MEMORANDUM
City Council Agenda Item

SUBJECT: Change request - Kennebec Street sidewalk material policy, 195 Kennebec Street

PROJECT: **CENTURY TIRE PLAZA**
195 KENNEBEC STREET, PORTLAND, ME
SHEET TITLE: **SITE LAYOUT AND UTILITY PLAN**
CLIENT: **NORTHLAND ENTERPRISES, LLC**

SHEET TITLE
SITE LAYOUT AND UTILITY PLAN

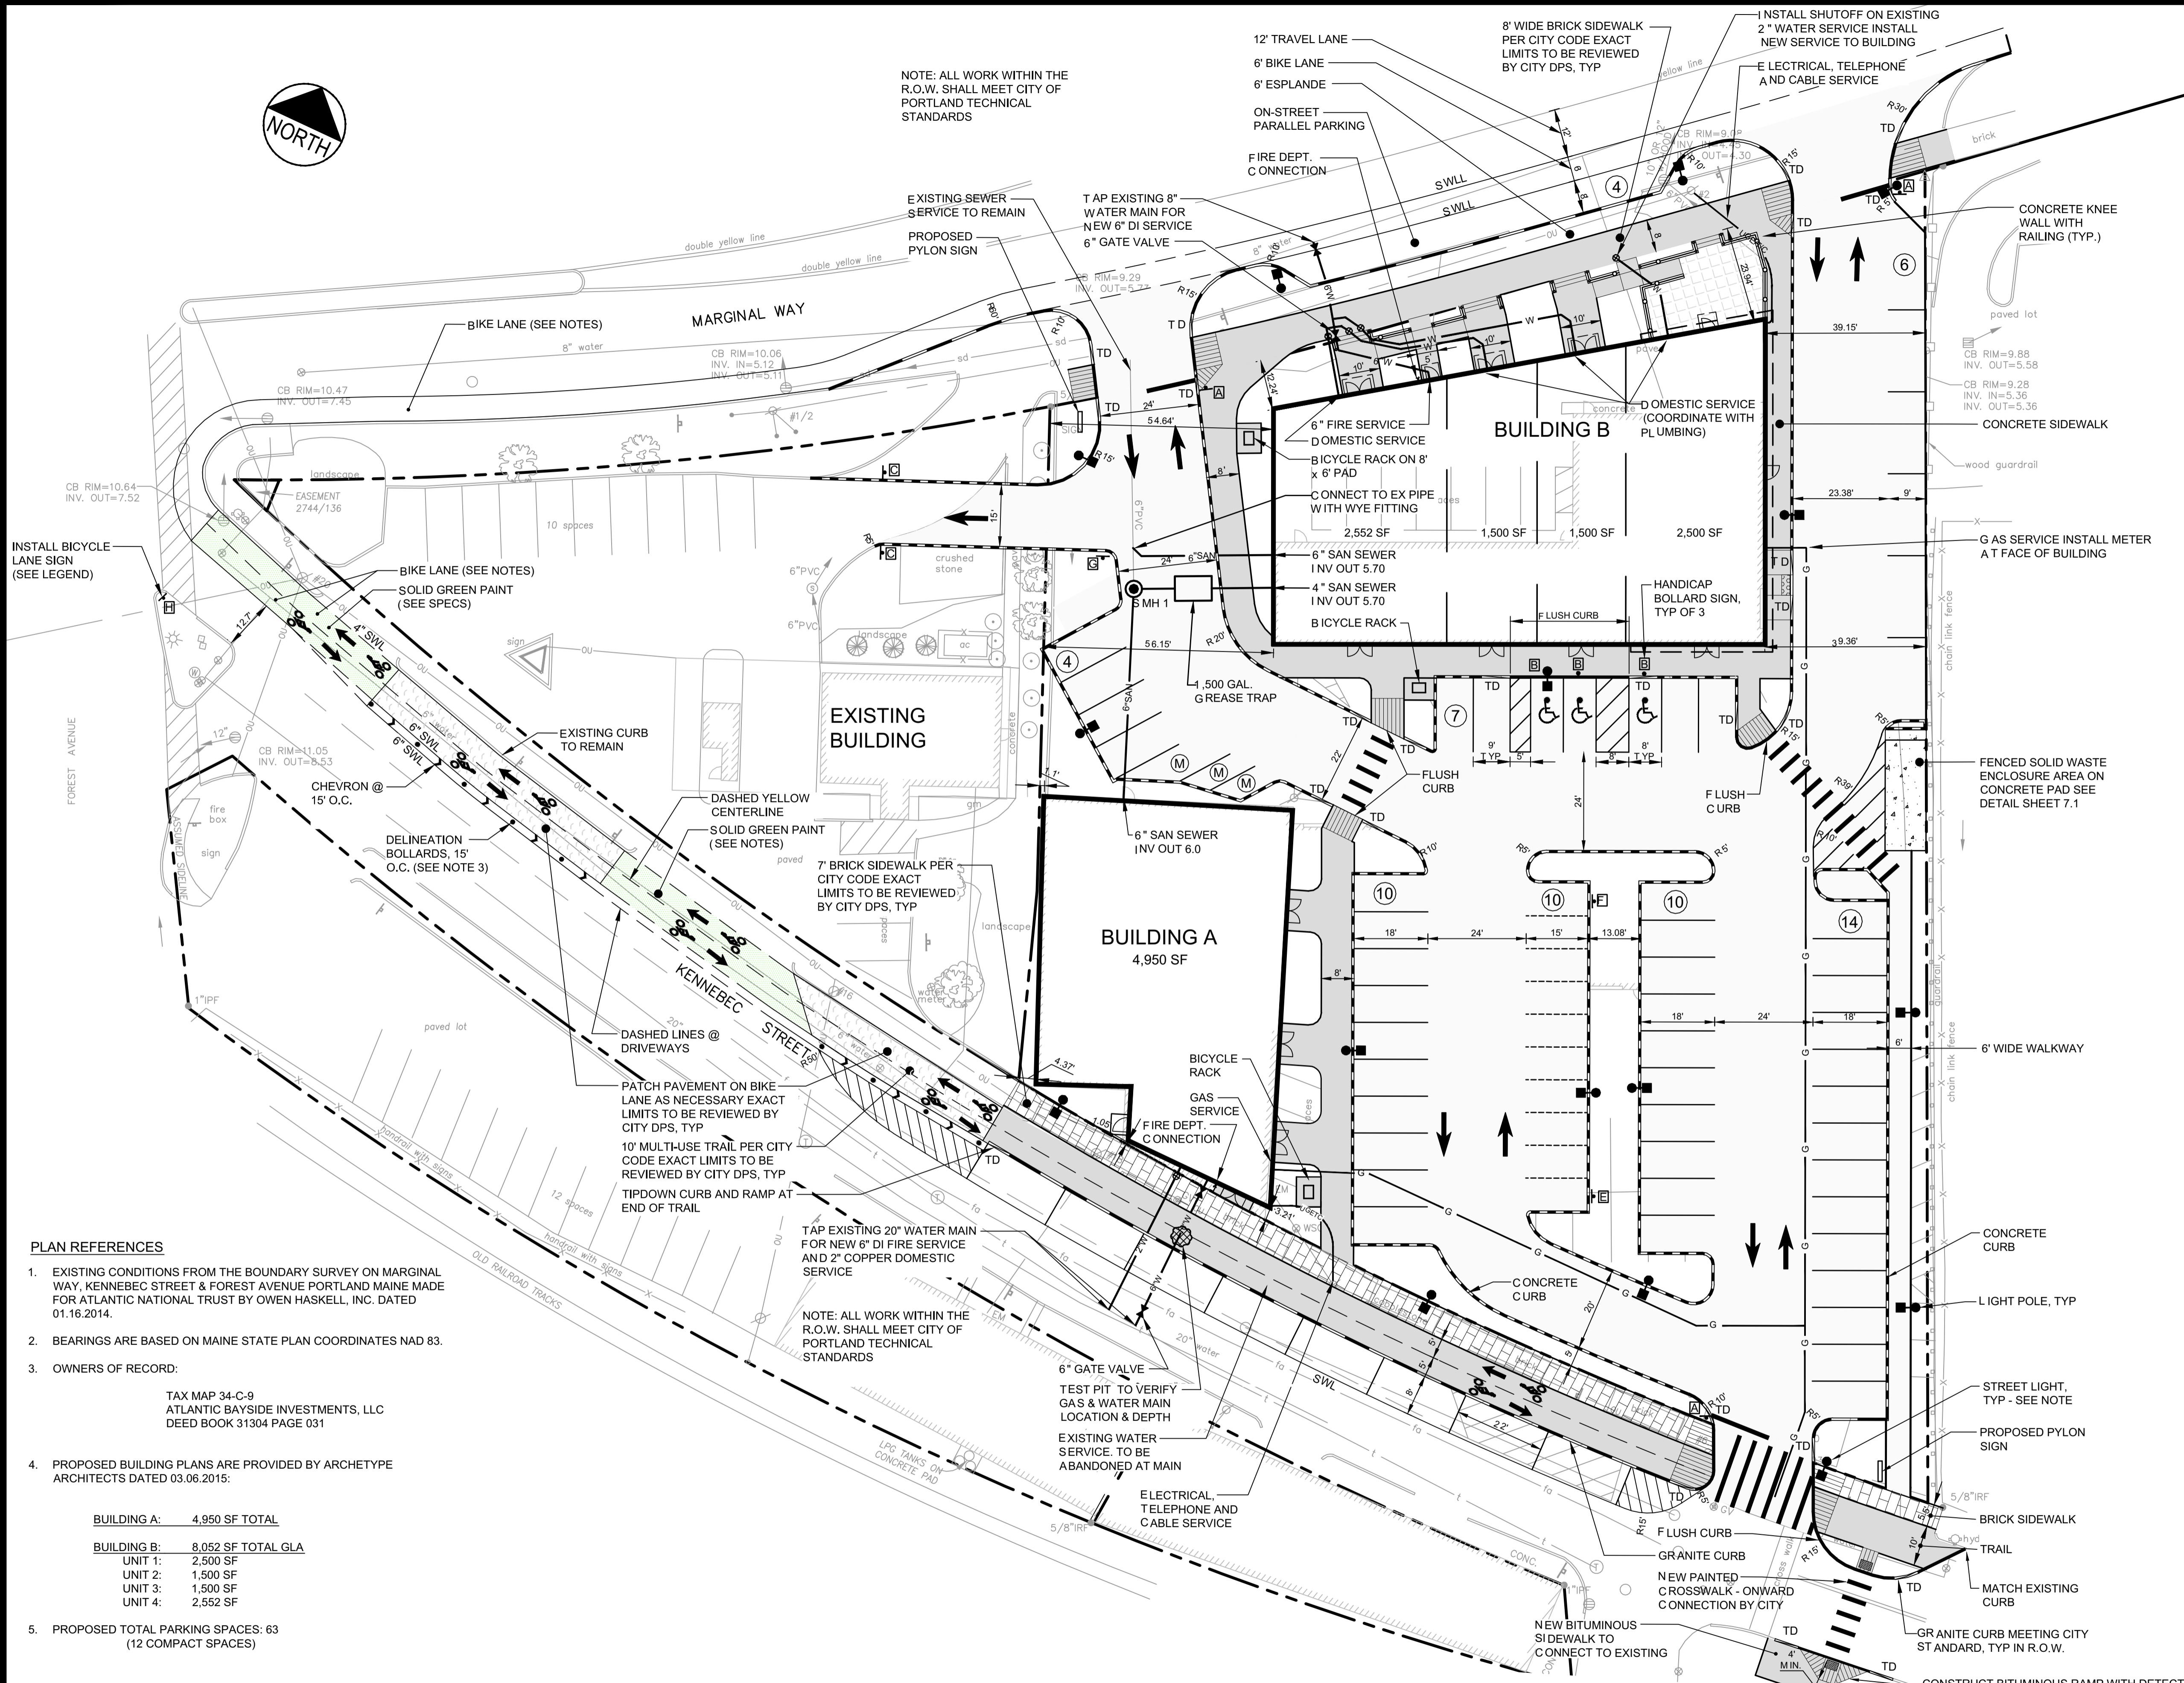
On April 14, 2015, the Planning Authority approved a Level II site plan for the redevelopment of the Century Tire site at 195 Kennebec Street. The plans included brick sidewalks, in accordance with the city's sidewalk material policy, on both the Marginal Way and Kennebec Street frontages of the site (*Attachment 1*). In the intervening time, the redevelopment project has been largely completed, save for the sidewalk on Kennebec Street. On March 30, the developer requested a change in sidewalk material for this frontage, stating that "the Kennebec side of the site would be better served by a concrete sidewalk [than a brick sidewalk]" (*Attachment 2*).

The developer has stated that “this change in material [from brick to concrete] will result in a public walkway that is safer and more consistent with the adjacent concrete sidewalks on Kennebec Street.” It should be noted that the sidewalks immediately east and west of the site, where they exist, are asphalt.

As discussed, on behalf of Vandelay Industries, the owner of 195 Kennebec Street, we would like to officially request a place on the April 24th City Council agenda in order to request a waiver to the City Material Policy for the portion of sidewalk we will be completing on the Kennebec Side of our site. We have completed the Marginal Way sidewalk in brick, but feel that the Kennebec side of the site would be better served by a concrete sidewalk. We feel this change in material will result in a public walkway that is safer and more consistent with the adjacent concrete sidewalks on Kennebec Street.

Staff supports a sidewalk material change from brick to concrete for Kennebec Street from Forest to Elm as shown in Figure 2, for the reasons noted above. Staff is in the outreach phase and may come forward with a more comprehensive recommendation regarding a change to the sidewalk policy in Bayside at a future date.
